PLANNING AMENDMENT

Application No: H19-0954-11/AI

Description: Proposed garage/implement store

Amendment: Additional building shown on plan (dwg. no. 2344-11-01A)

SITE LAYOUT PLAN.
1/500.

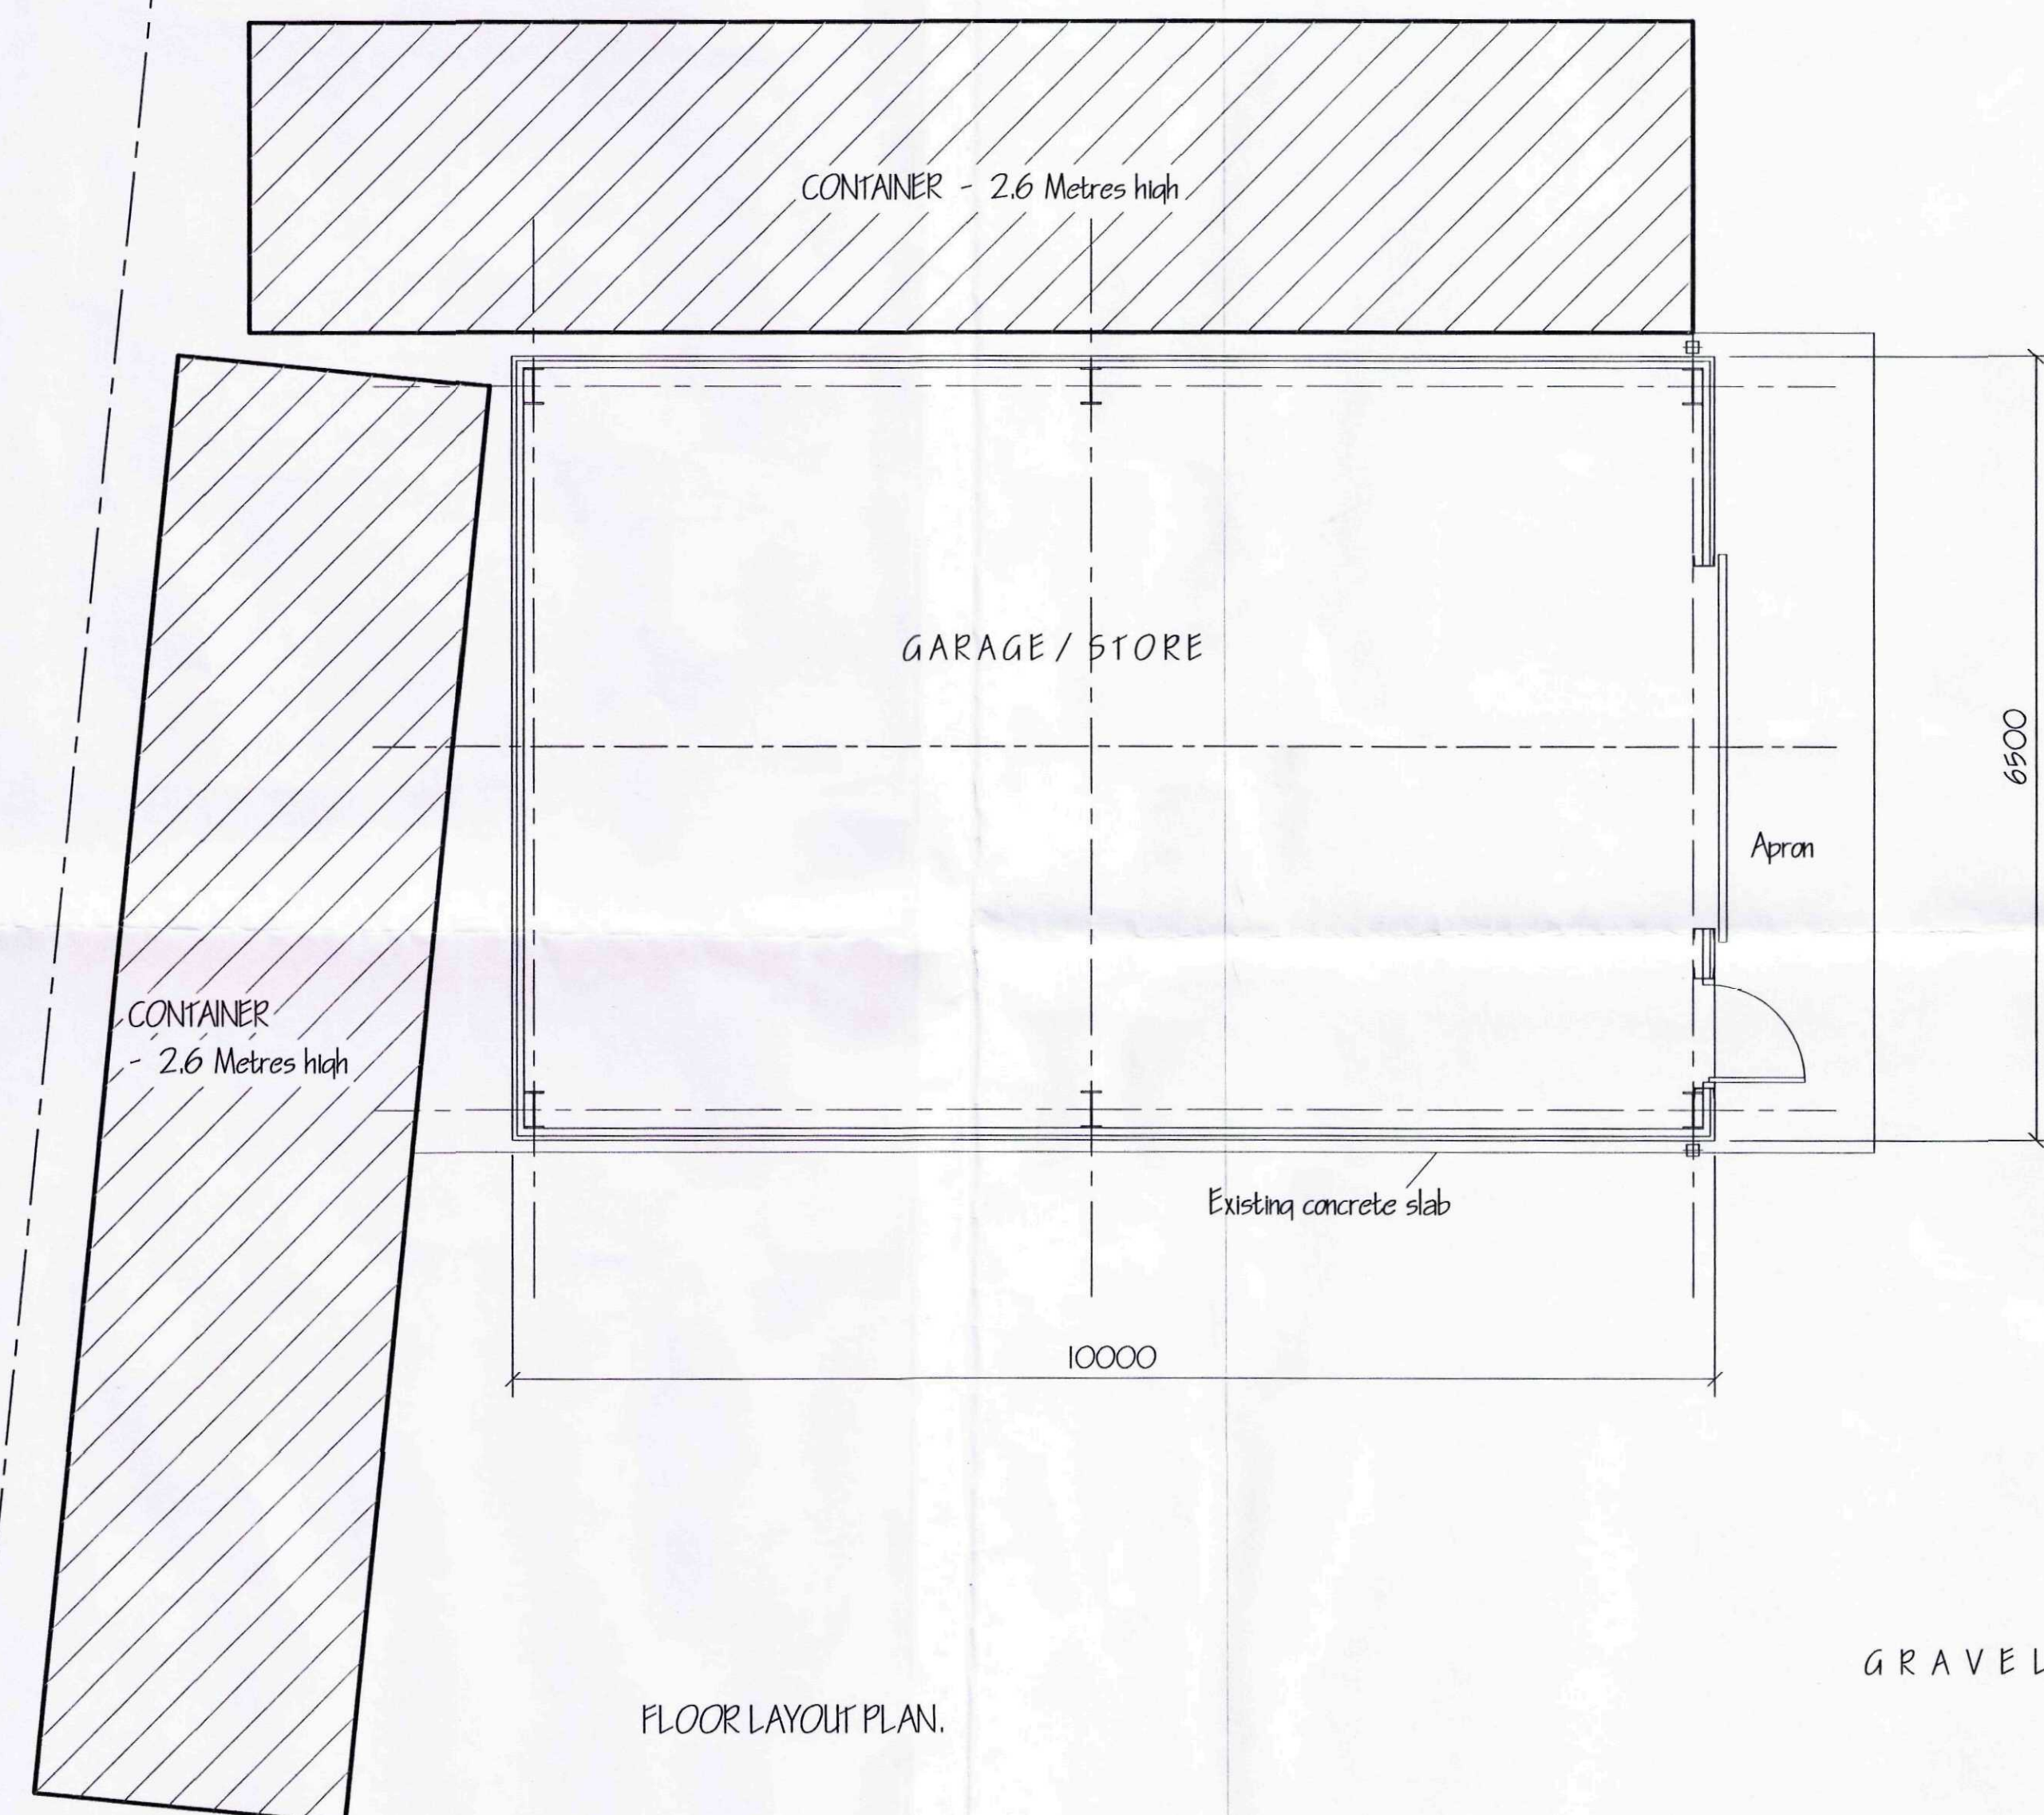
Please indicate on the submitted drawings all of the existing buildings/containers on the site and which will be removed because there does appear to be an issue of cumulative impact. Is any planting proposed?

It is assumed that all of the existing containers on the site will be removed as a consequence of the new building. If not, what are they currently used for and how long have they been in situ.

Please find attached amended plan showing the existing storage units on site that will be removed when the garage / store has been completed.

The two white containers have been on-site for approximately 12 years and contain general household chattels, the intention is that these will remain. Mr Wright informs me there are two smaller sheds/containers on site which will be removed when the proposed building is completed.
